**ITEM # 13**

**PROJECT # 1004338**

**APPLICATION # 05-01186**

**RE: Tracts 1-A & 1-B, Quarter Horse Acres/minor plat**

PLAT OF
LOTS 1-A-1 AND 1-B-1
QUARTER HORSE ACRES

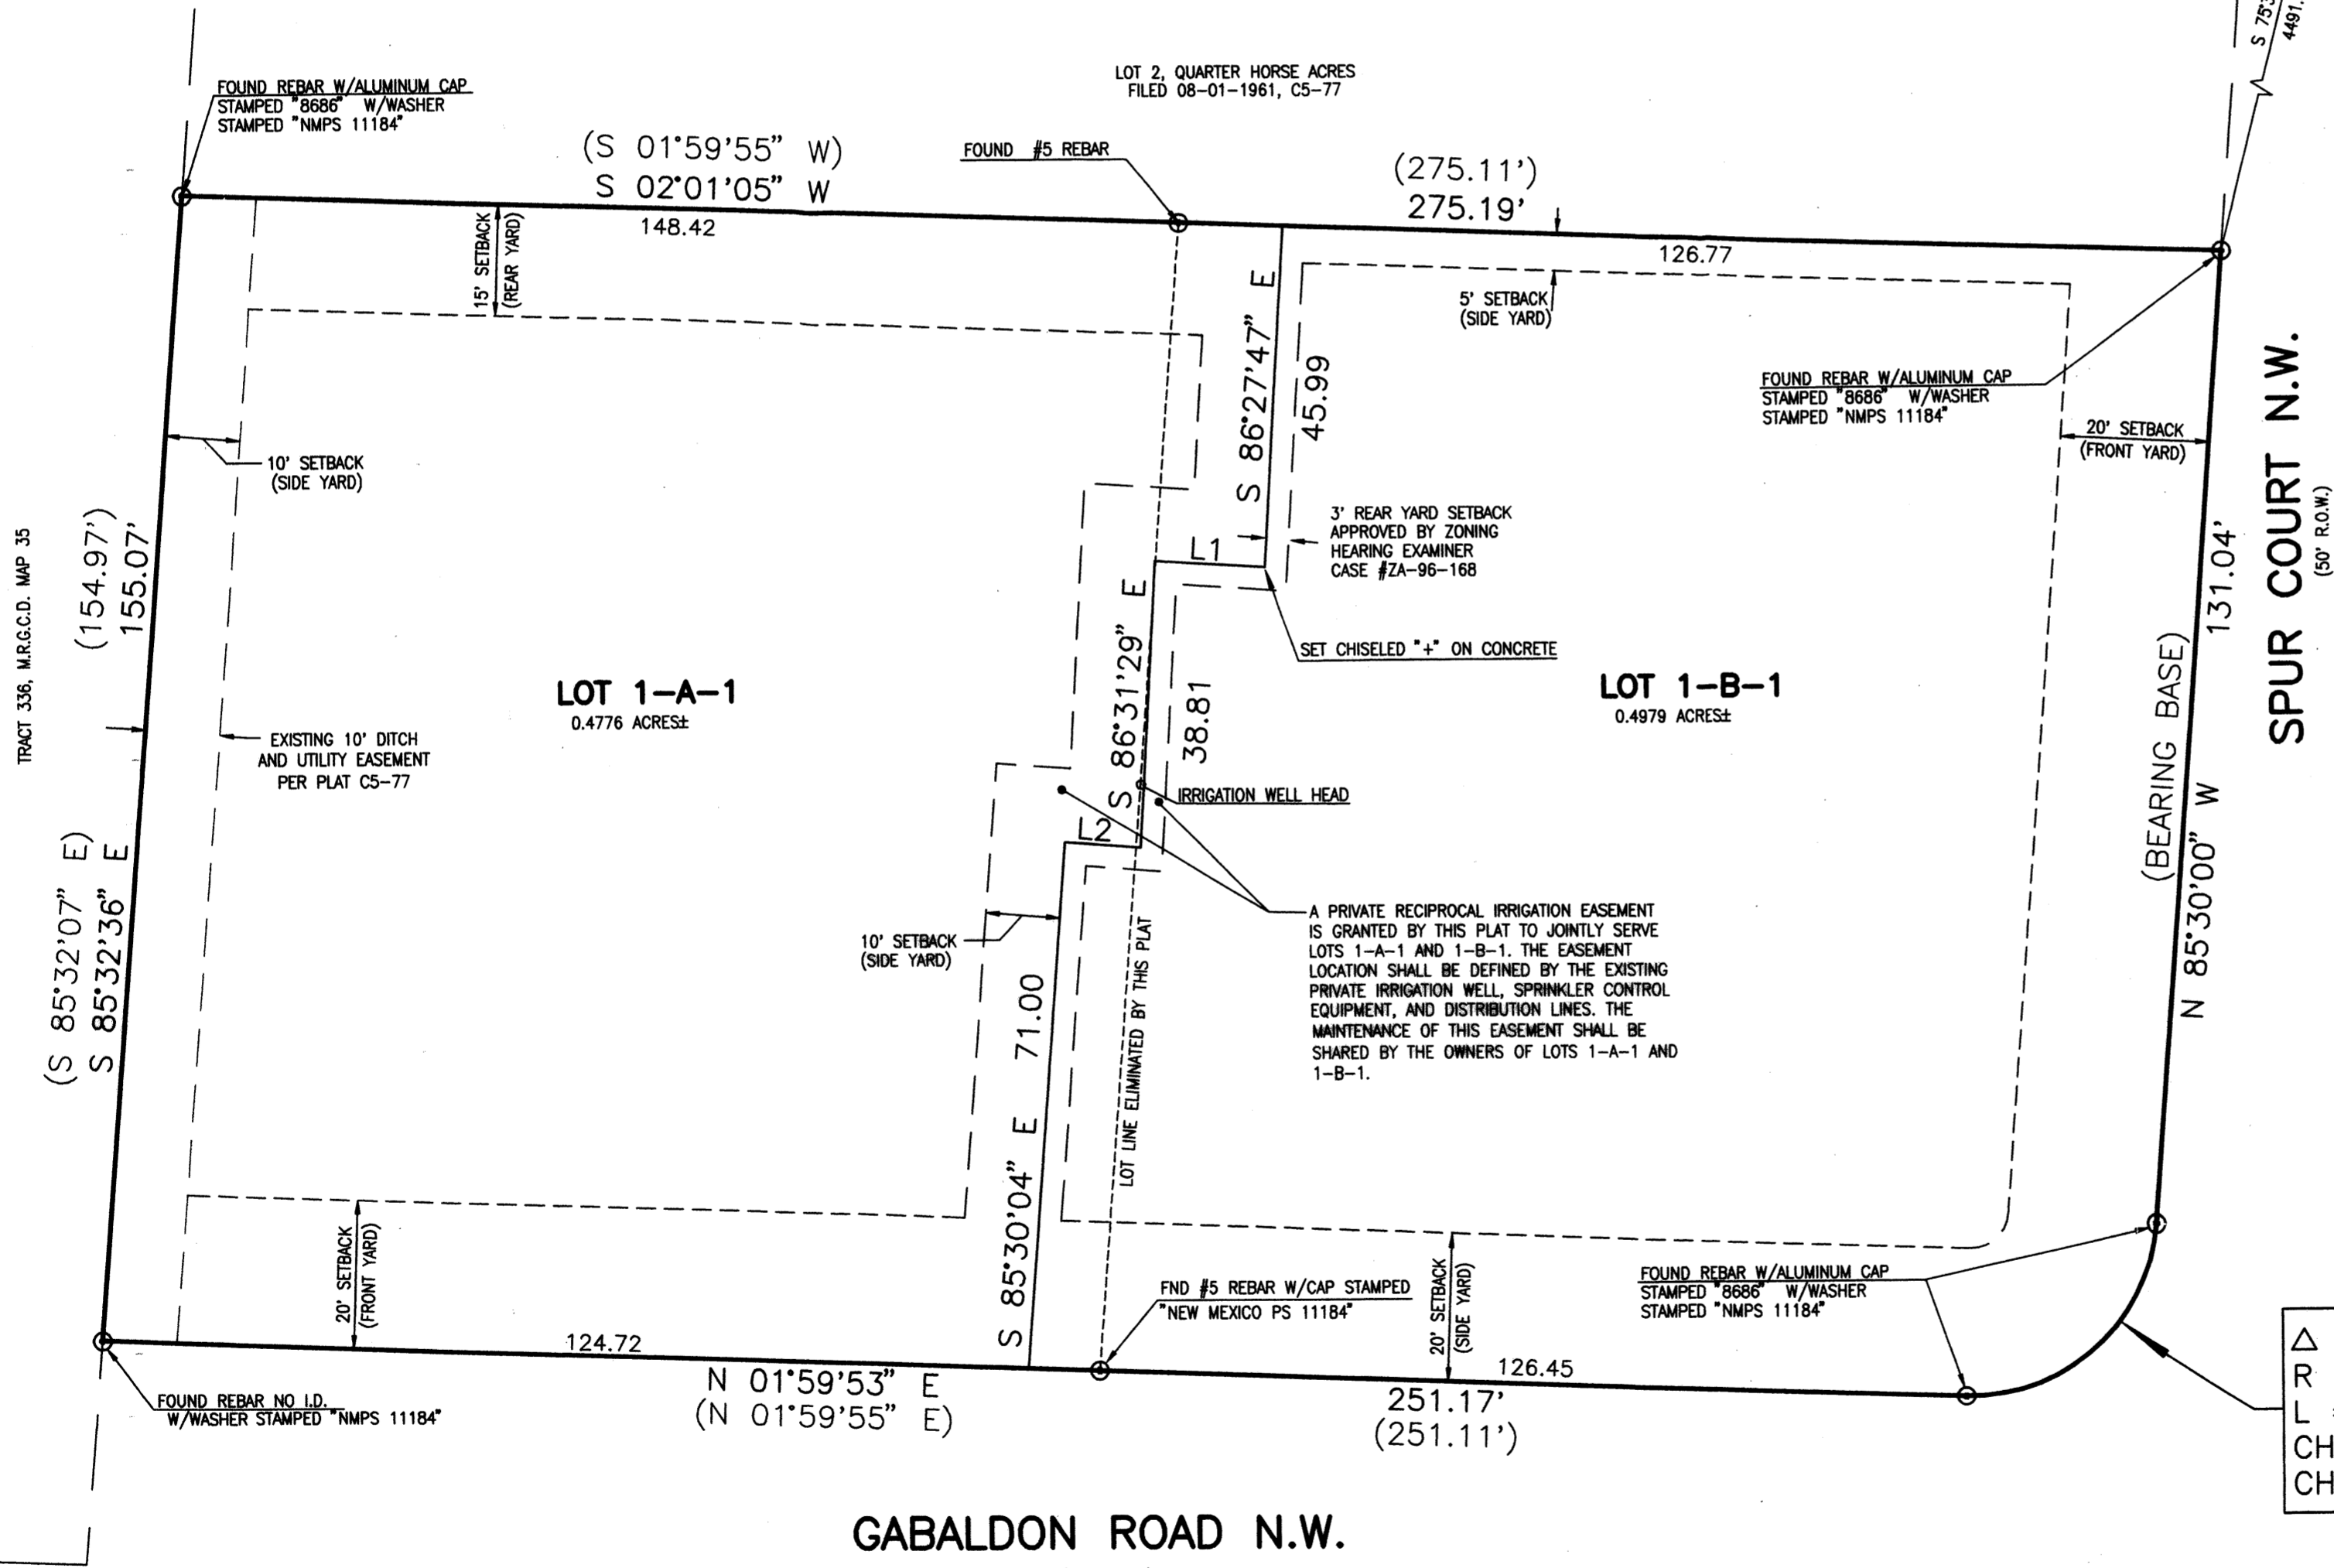
Are all the required setbacks met with this lot line change?

The current zoning should be included in the Notes on the plat.

AGIS dxf approval is required for Planning to sign the plat.
